Application Ref:	3/2025/0323			 <div>Ribble Valley Borough Council</div> <div>www.ribblevalley.gov.uk</div>
Date Inspected:	02/06/25	Site Notice:	N/A	
Officer:	LW			
DELEGATED ITEM FILE REPORT:				APPROVAL

Development Description:	Proposed first floor infill extension to rear. Single storey extension to rear across the full width of the house.
Site Address/Location:	1 Northacre Drive, Barrow, BB7 9XT.

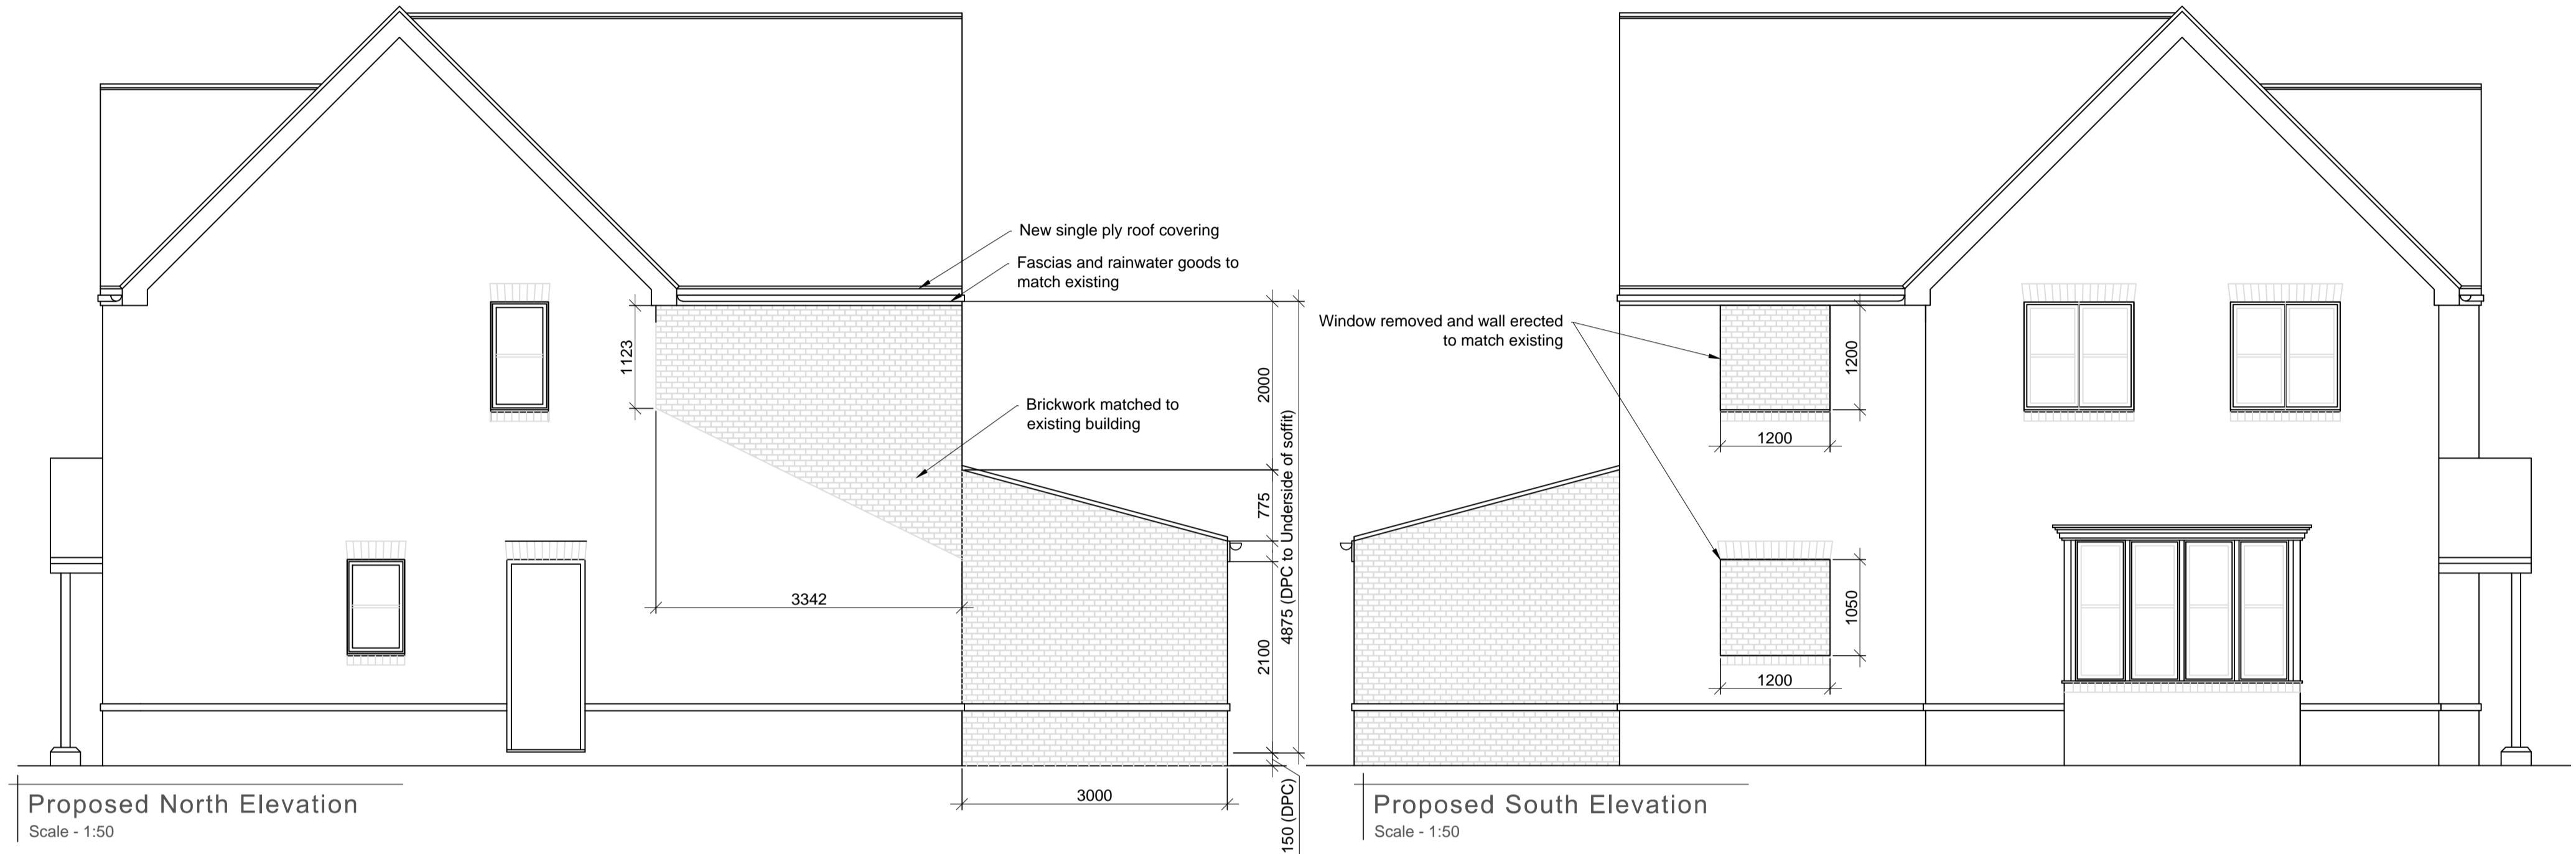
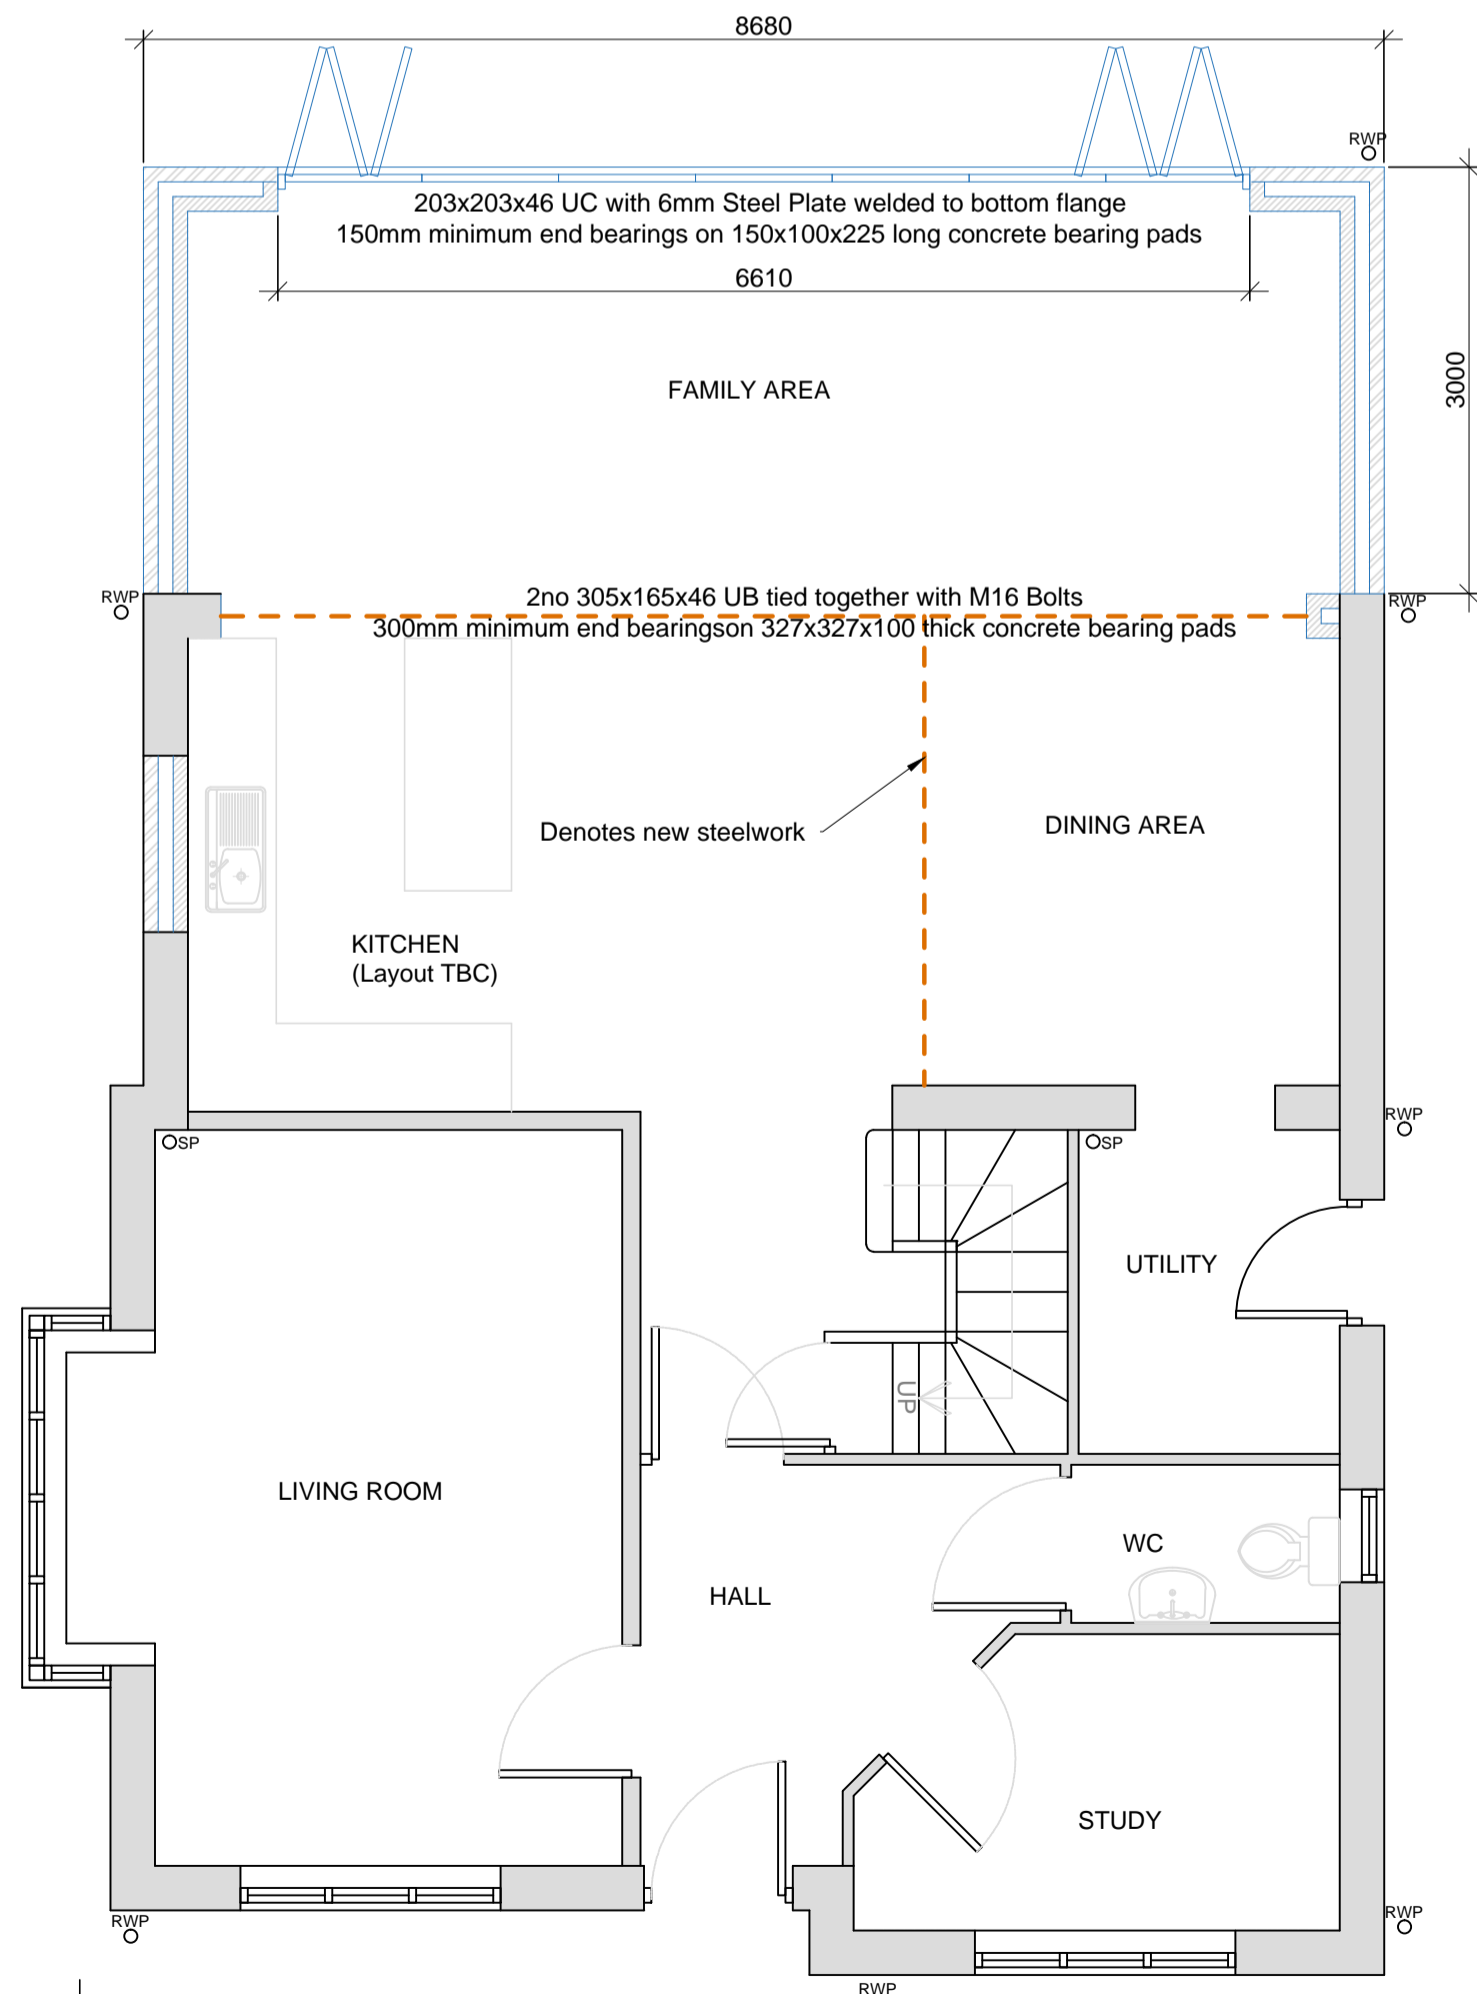
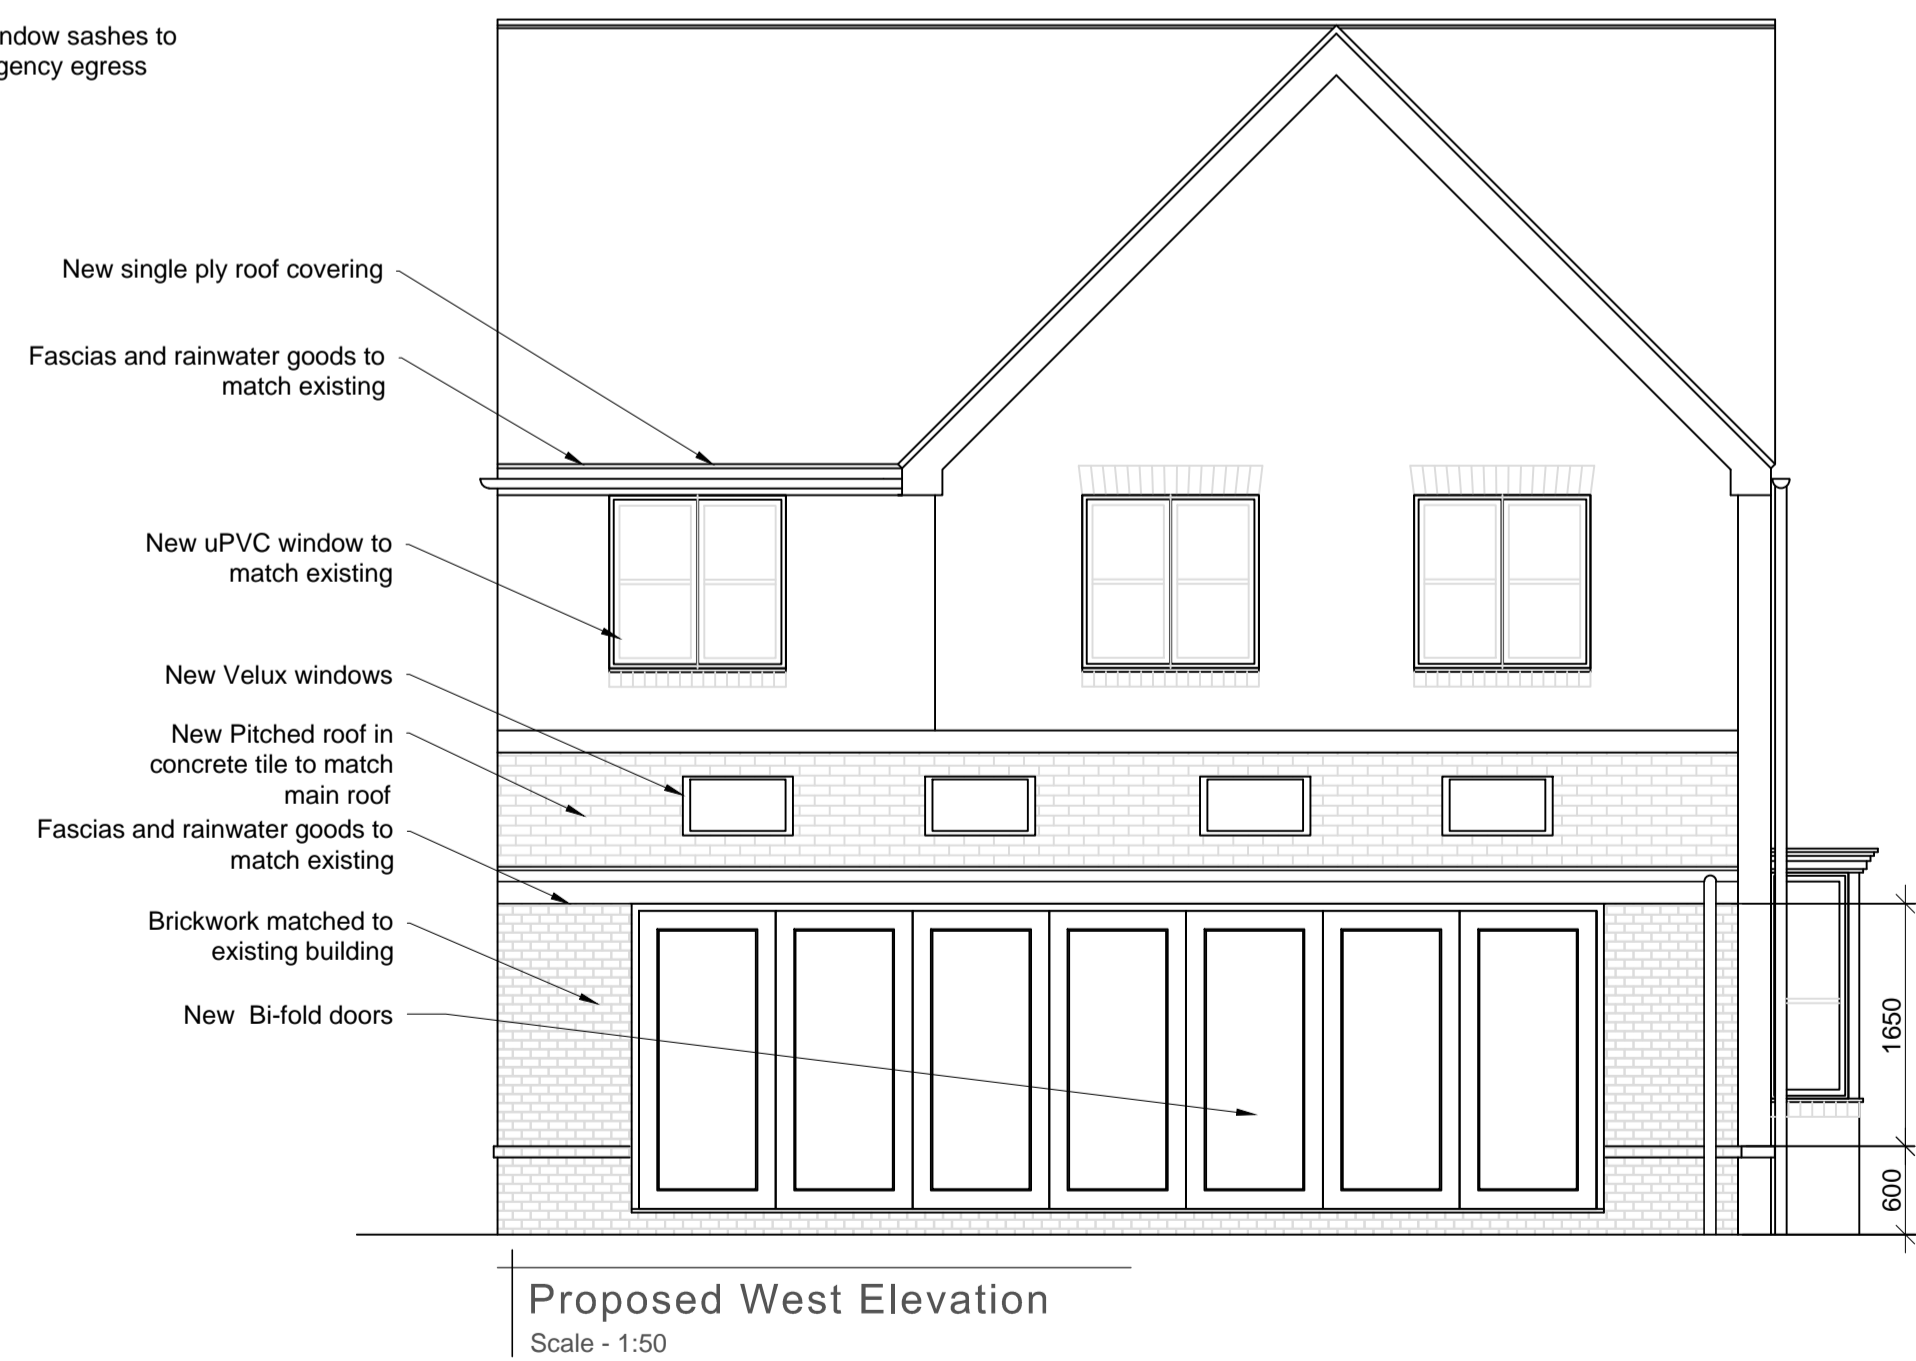
The proposed development as originally submitted was not considered to comply with the above. Whilst the size, scale, and materiality of the first-floor extension was deemed to be appropriate and in proportion with the existing dwellinghouse, the incorporation of a proposed flat roof form was considered to result in an unsympathetic and poorly designed form of development due its visual relationship with the existing pitched roof forms of the application dwelling.

In addition to the above, there were also concerns regarding the impact of blocking up of 2no. windows to the southern roadside frontage of the dwelling. Whilst it is acknowledged that this element of the original proposal may fall to be permitted development, as the proposed alterations had been submitted as part of the planning application, and shown on the submitted plans, then an assessment of the impact upon external appearance and visual amenity was required.

In this respect, although it is recognised that a number of nearby dwellings benefit from a single blocked up window at first floor, these are understood to have been included as part of the original design of a minority of house types within the housing development. Notwithstanding this, the proposed alterations at the application property included the blocking up of both the ground and first floor openings featured to the southern side elevation of the property, directly fronting Middle Lodge Road. The proposed alterations, if implemented, would therefore take a visually prominent position with the existing street scene, resulting in a large expanse of solid wall which would appear at odds with the solid-to-void ratio featured to the remainder of the application dwellinghouse.

In view of the above, it was determined that the originally proposed first floor extension, by virtue of its flat roof form, would result in an unsympathetic and poorly design from of development, which together with the blocking up of the 2no. windows to the southern elevation of the main dwellinghouse, would result in poor design, harmful to the visual amenities of the host property and surrounding area.
